Application for removal or variation of a condition following grant of
planning permission. Town and Country Planning Act 1990.
Planning (Listed Buildings and Conservation Areas) Act 1990

Number	
Suffix	
Property name	Buttercup Barn
Address line 1	Parsonage Lane
Address line 2	Tydd St Mary
Address line 3	
Town/city	Spalding
Postcode	PE12 0JA

Proposed conversion of existing redundant agricultural buildings into new dwelling	
Reference number	
H21-0550-19	
Date of decision (date must be pre-application submission)	29/05/2019
Please state the condition number(s) to which this application relates	
Condition number(s)	
2

Client:
MR & MRS BAINES
Project:
PARSONAGE FARM BARN,
PARSONAGE LANE, SUTTON ST JAMES
SPALDING, LINCOLNSHIRE, PE12 0JA
Drawing Title:
PROPOSED ELEVATIONS

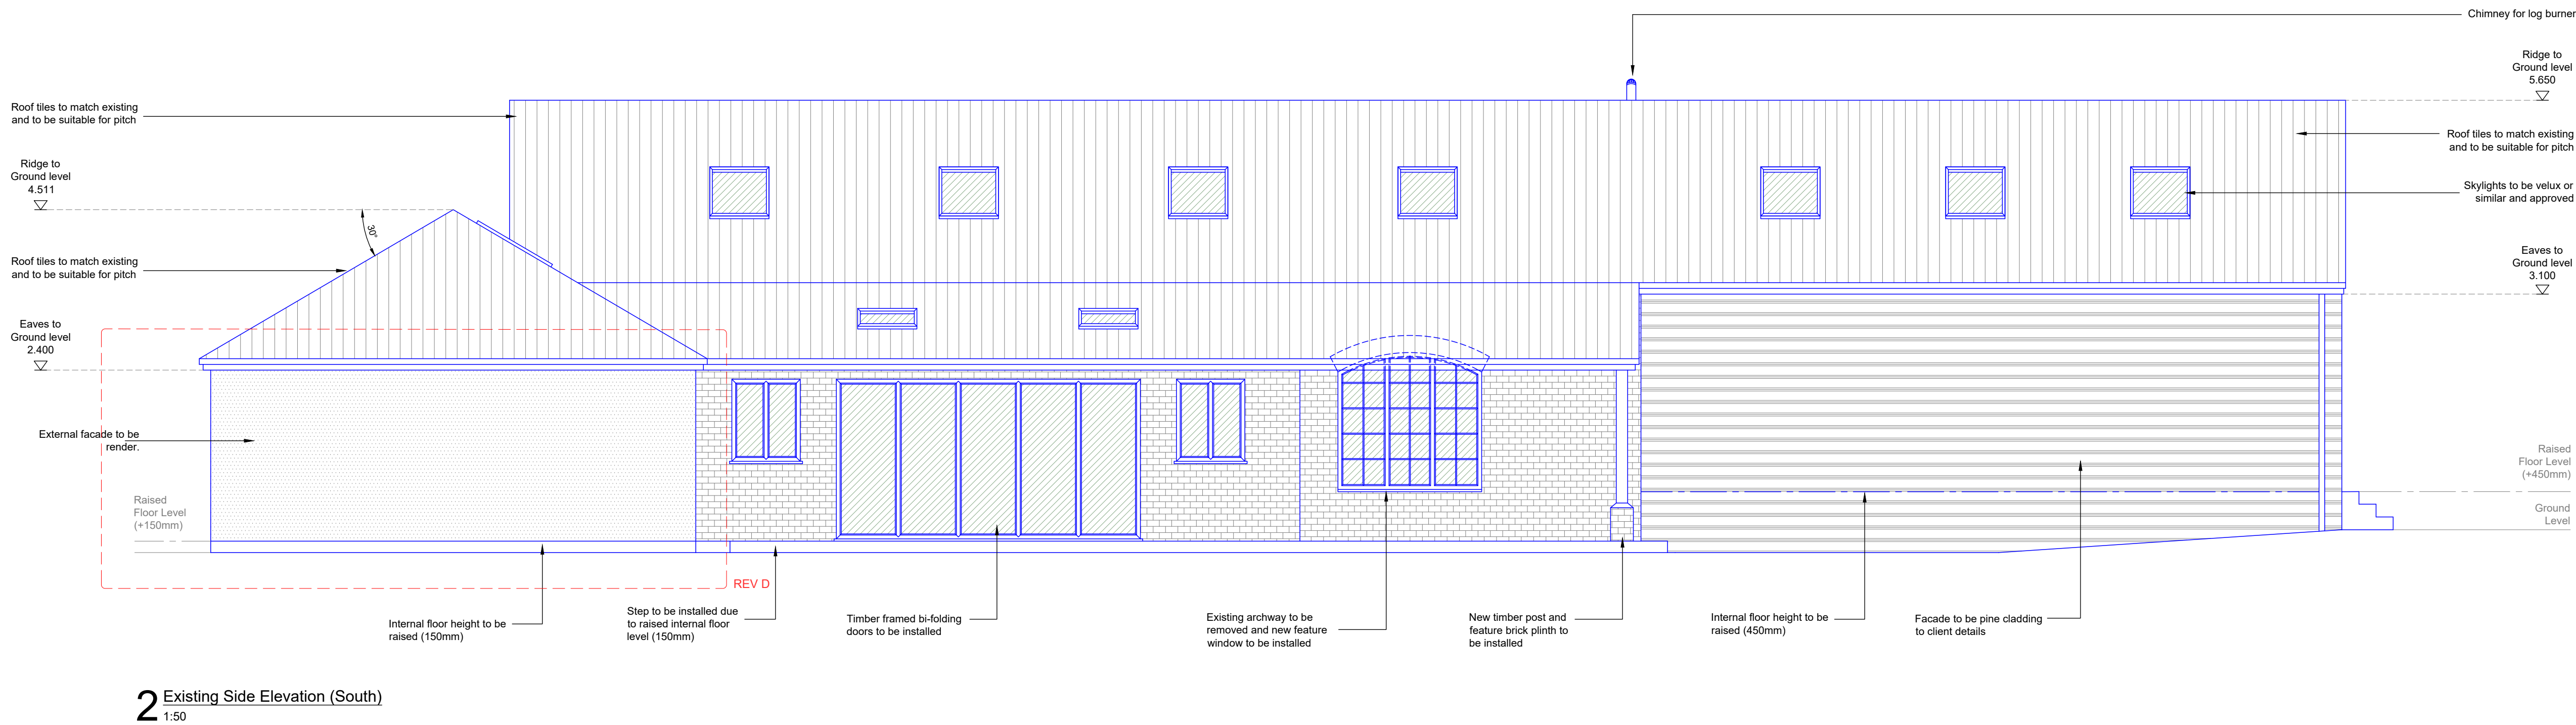
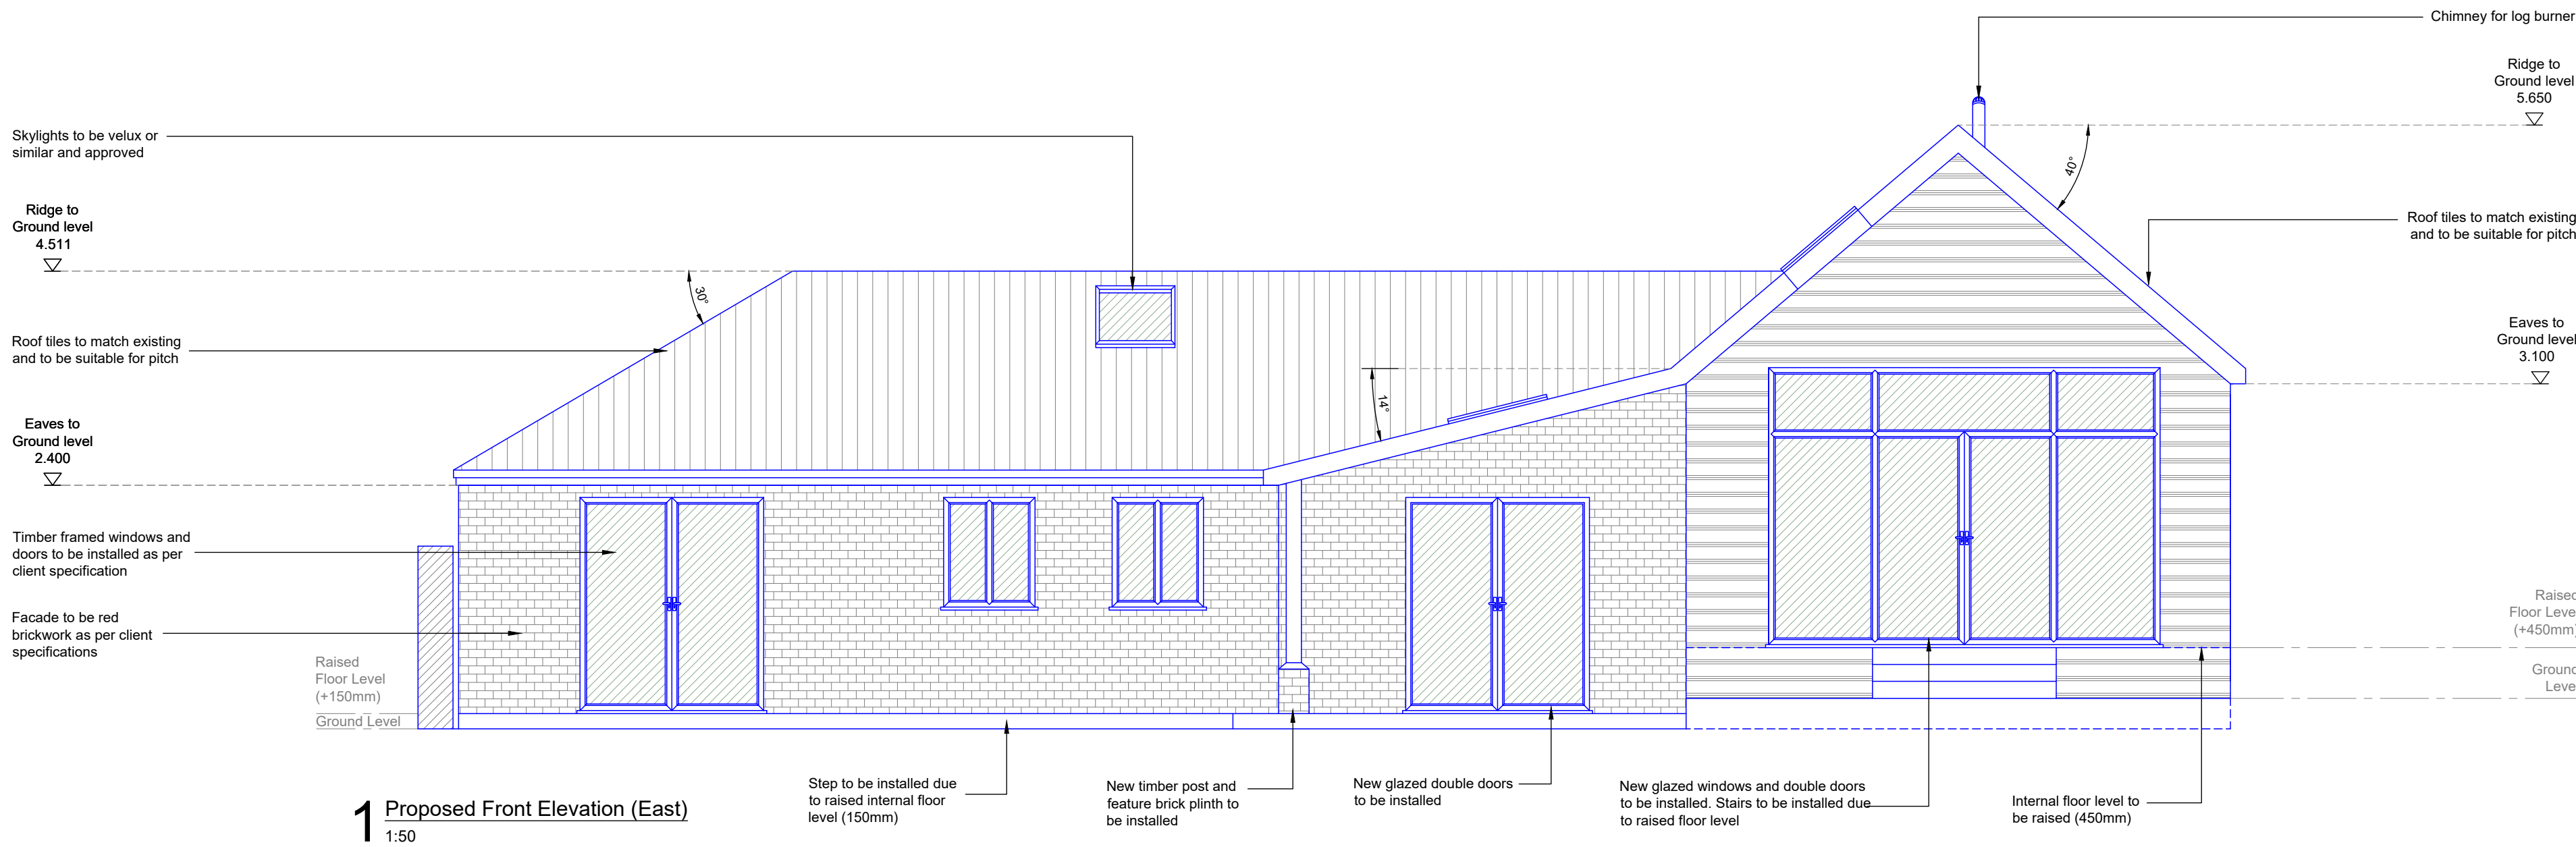
1. Roof line is same as originally proposed, there is no overhang to the neighbour; the only change is external wall. Originally fence wall supposed to be used for support roof however it collapsed before work started so we step back by about 400mm and build completely new wall, hence the overhang

2. back wall is rendered as it wasn't original one which collapsed. We used only original reclaim bricks on site and there was non left to construct that wall hence we used block and render. However wall is stepped back by thickness of the original fence wall so if in future someone wish to put this wall back in bricks it is possible. The reason why we choose this wall to be non-brick is that you cannot see it from the road and next to that wall neighbour build high level fence so no one actuality can see it

Project
**PROPOSED CONVERSION OF
EXISTING REDUNDANT
AGRICULTURAL BUILDINGS
TO NEW DWELLING,
PARSONAGE FARM,
PARSONAGE LANE,
TYDD ST MARY, LINCS.
SITE LAYOUT**

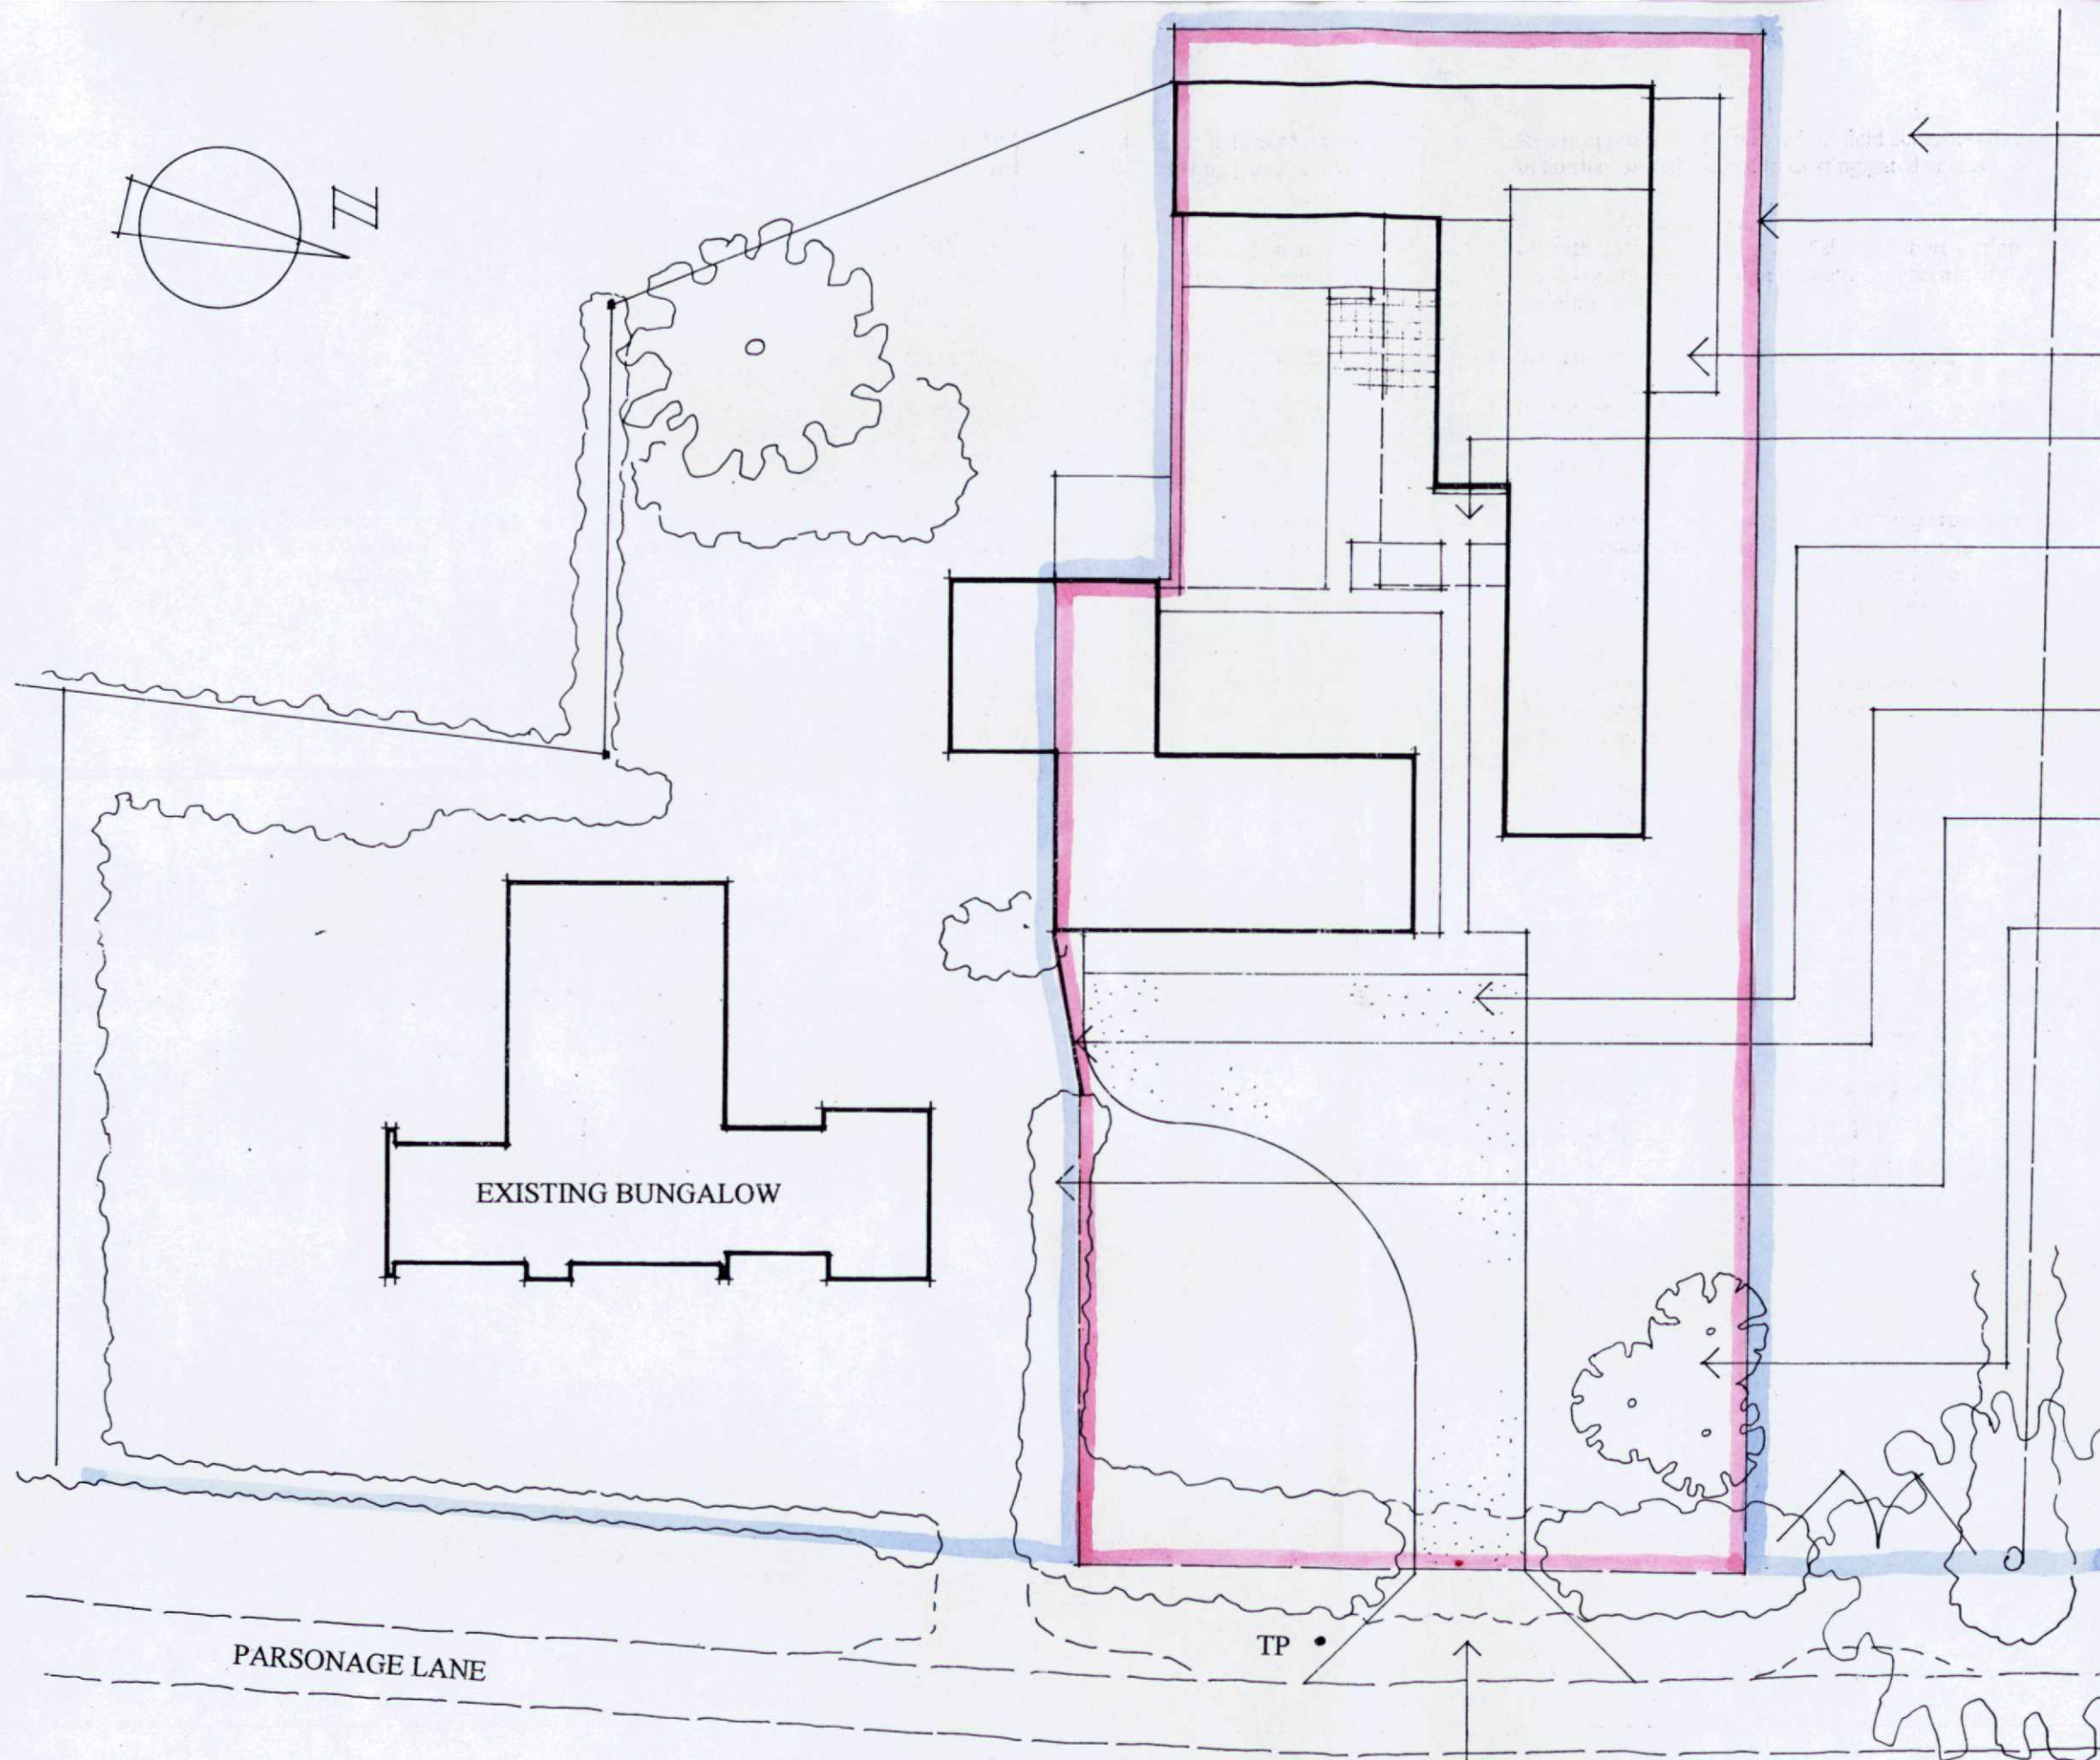
3. Site levels wasn't change much there was only minimal amount of top soil used and landscaping done in order to form a low level bank 600mm which will act as a boundary fence. Site levels wan't changed except newly formed bank. New Owner wants to keep original look of the barn without building any fences hence idea of low level bank
